**FINAL DRAINAGE REPORT  
FOR  
SOLACE APARTMENTS**

**November 25, 2020  
Project No. 25174.00**

PCD File No. PPR-20-047

50 25 0 50 100  
ORIGINAL SCALE: 1" = 50'

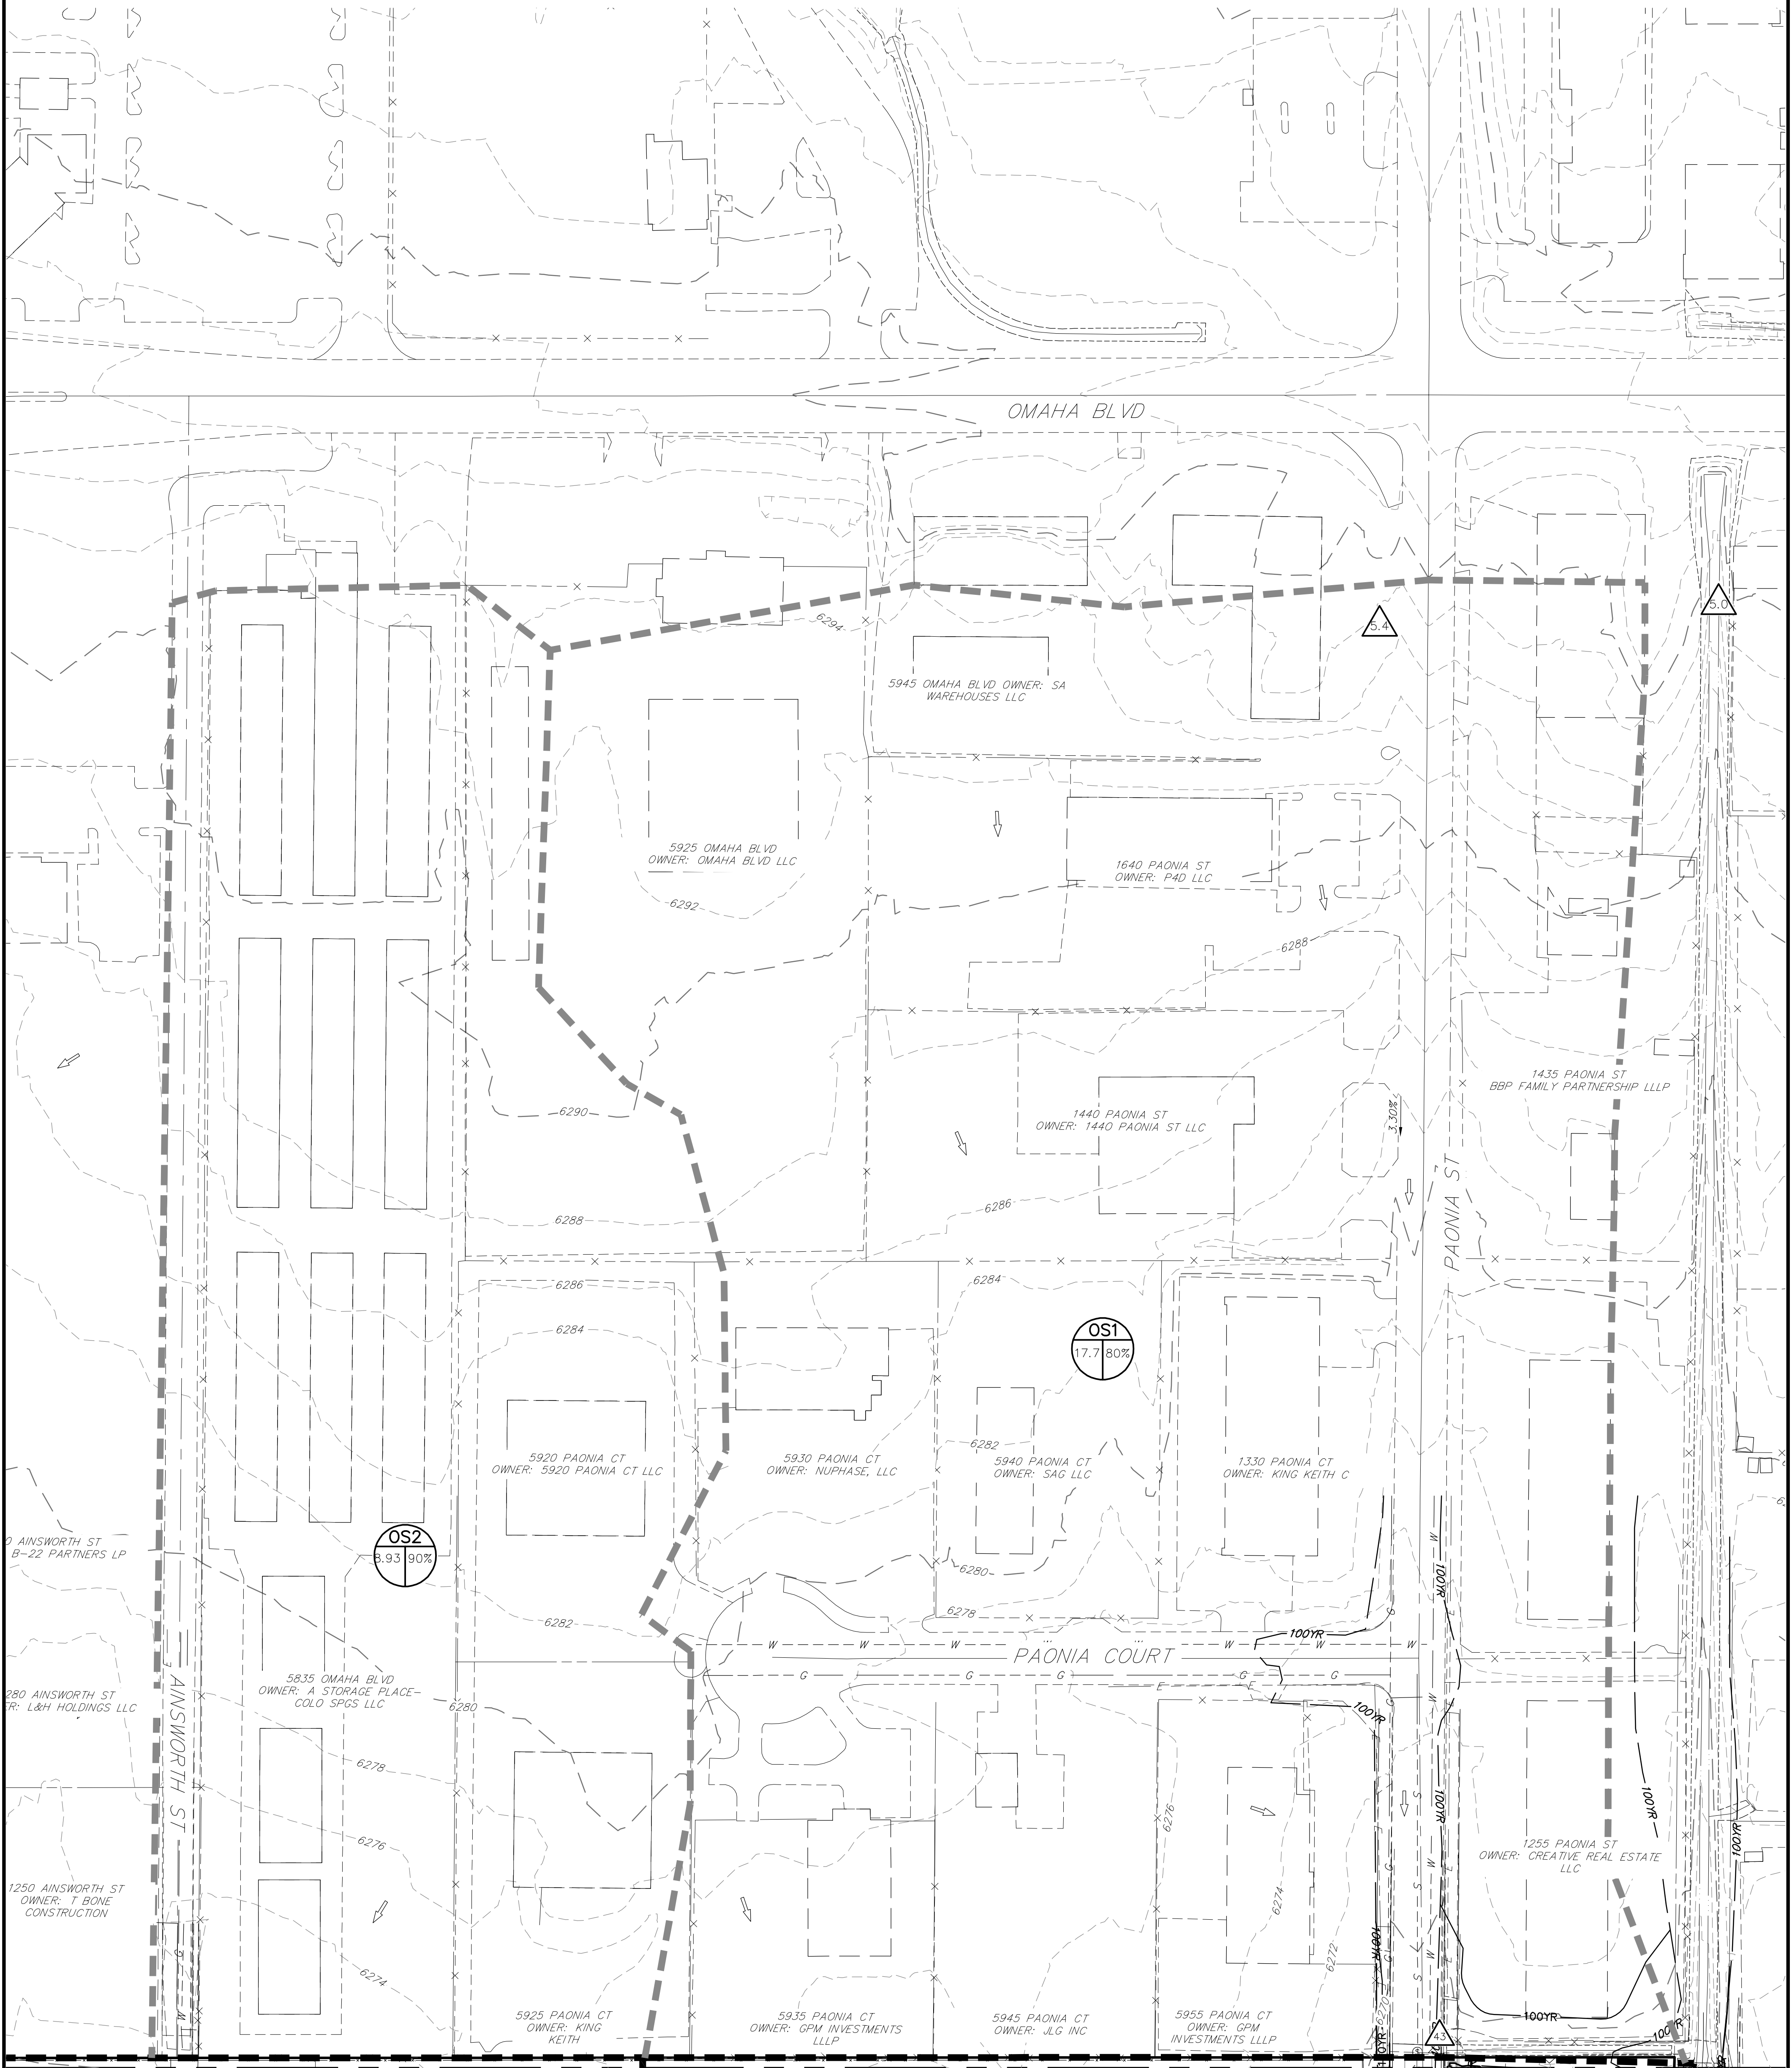
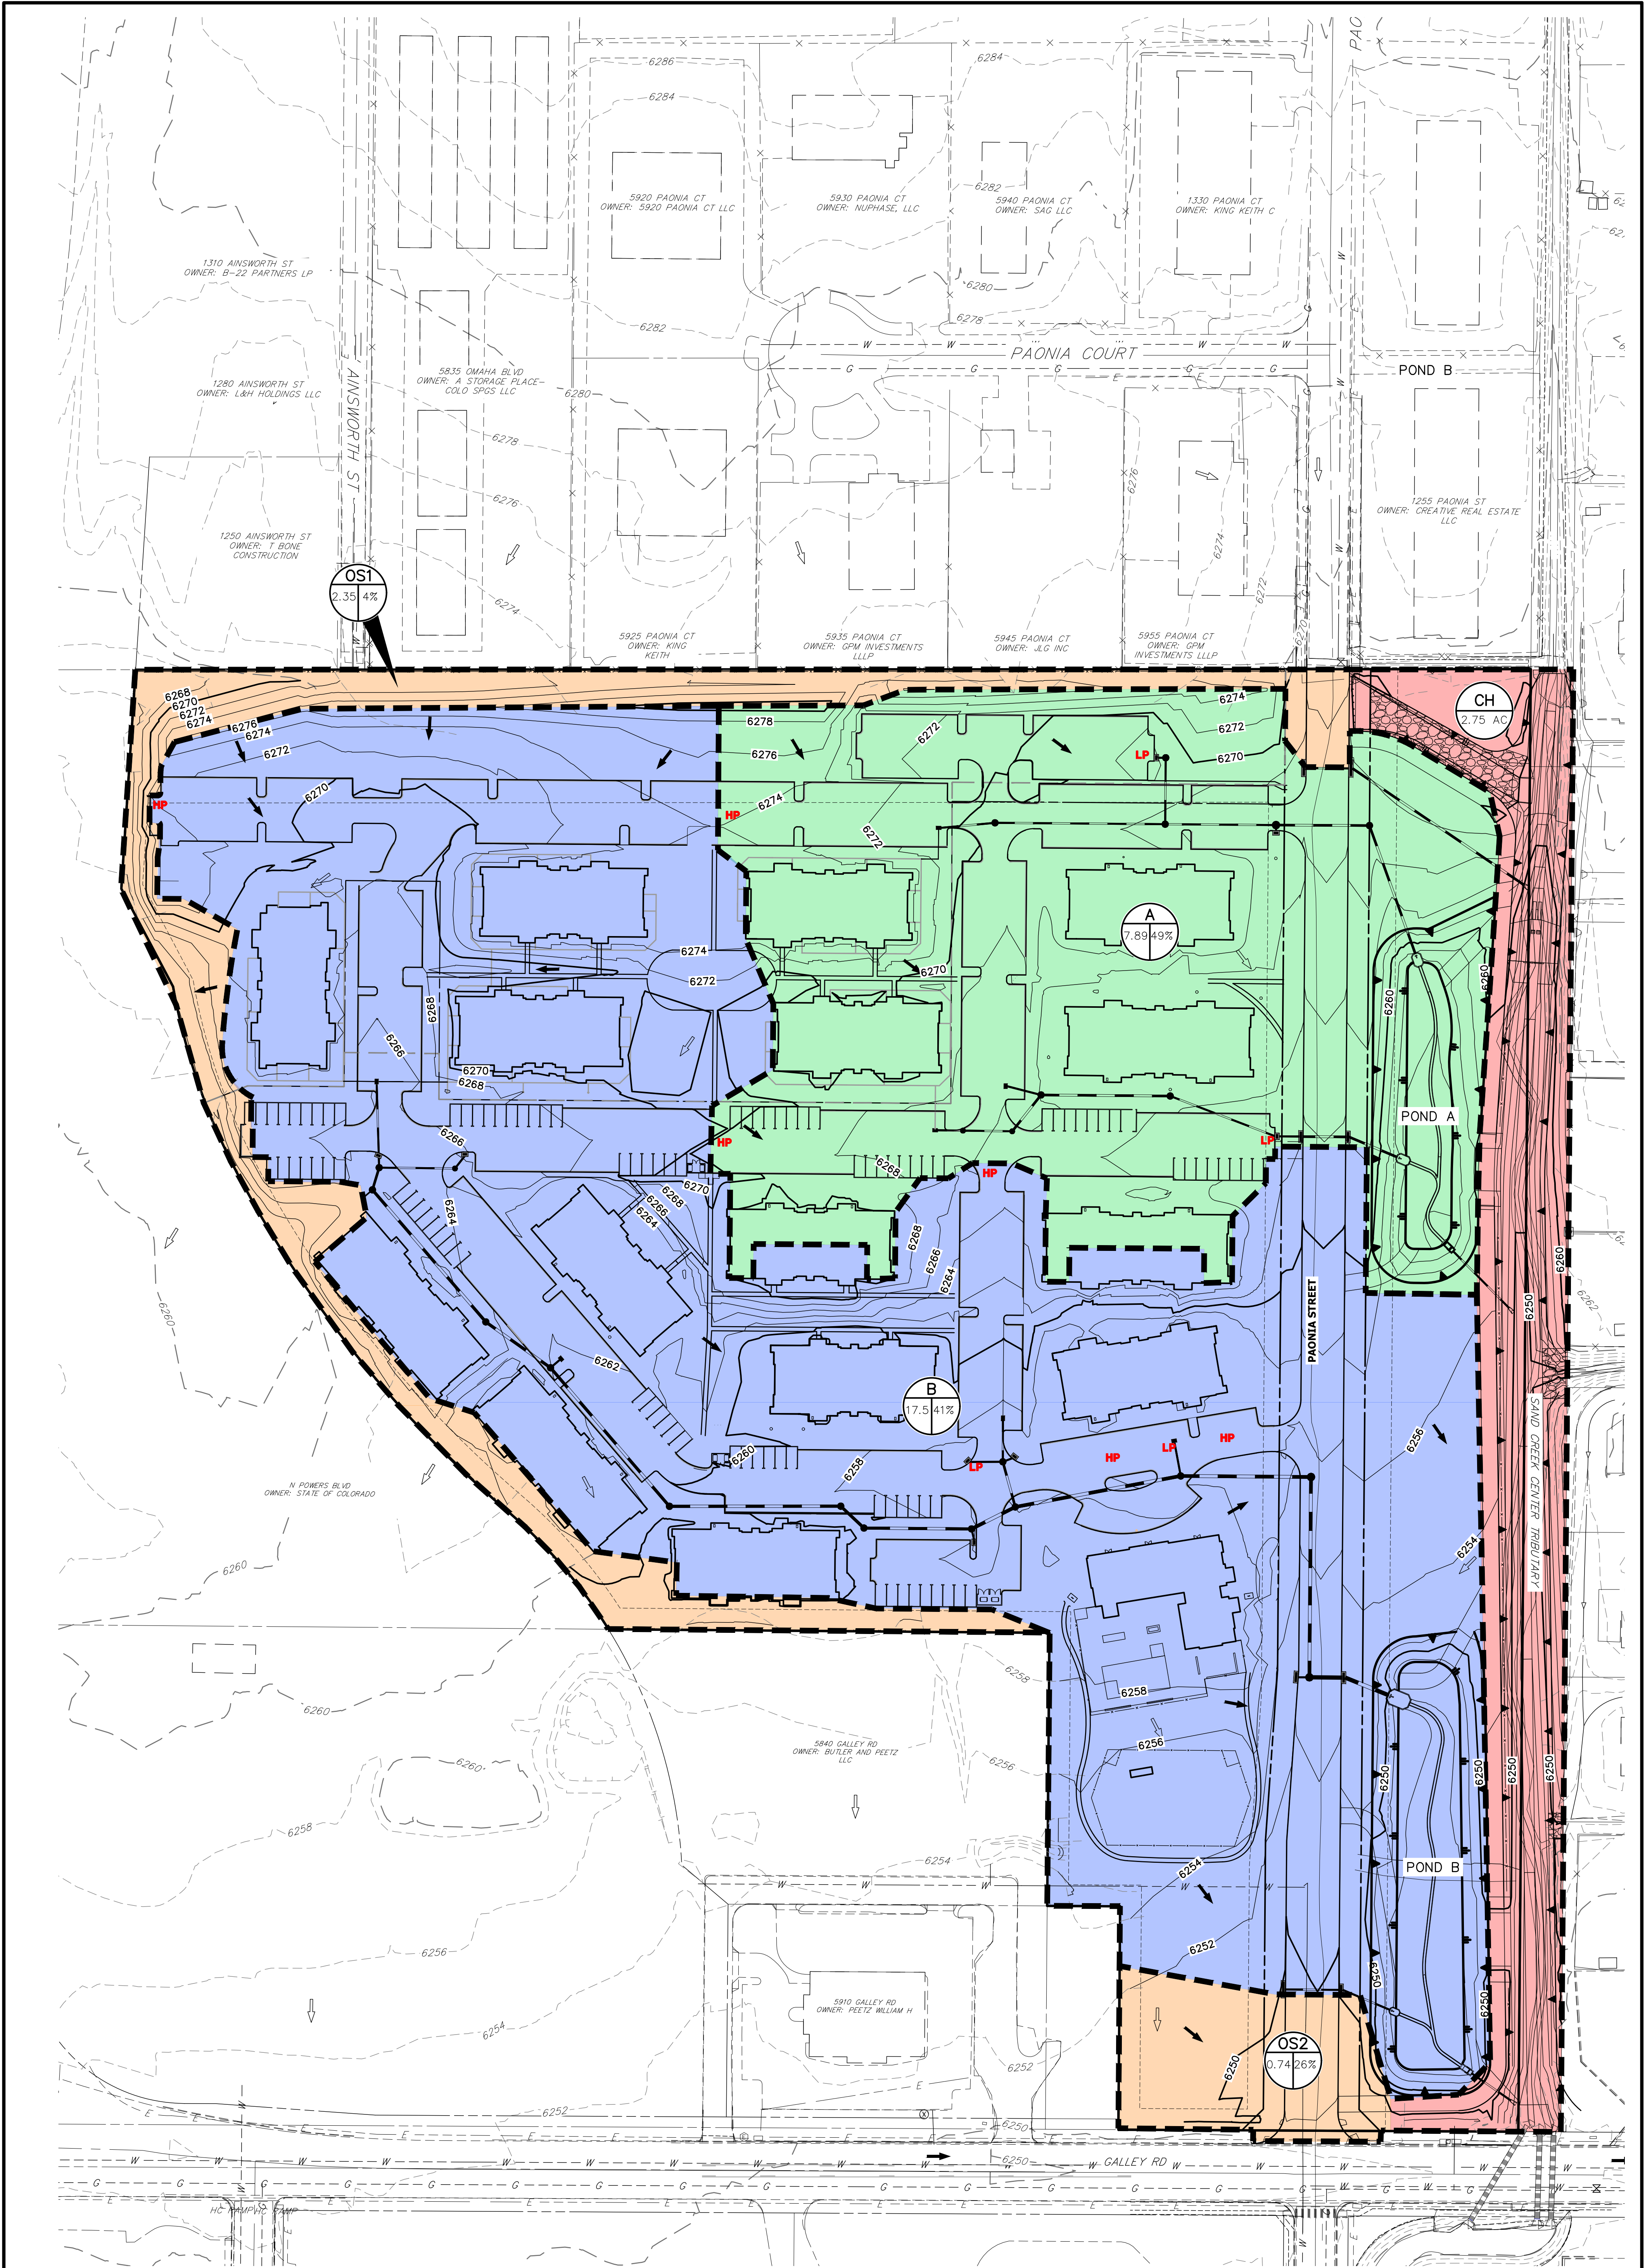
Please revise your description as the drainage map indicates 41% impervious. If this is correct then the basin wouldn't be primarily paving.

0.37 is indicated in the drainage map. Revise accordingly so that they match.

0.35 is indicated in the drainage map. Revise accordingly so that they match.

DP41 was not found on the drainage plan. pLease provide

Please show this DP on the plan
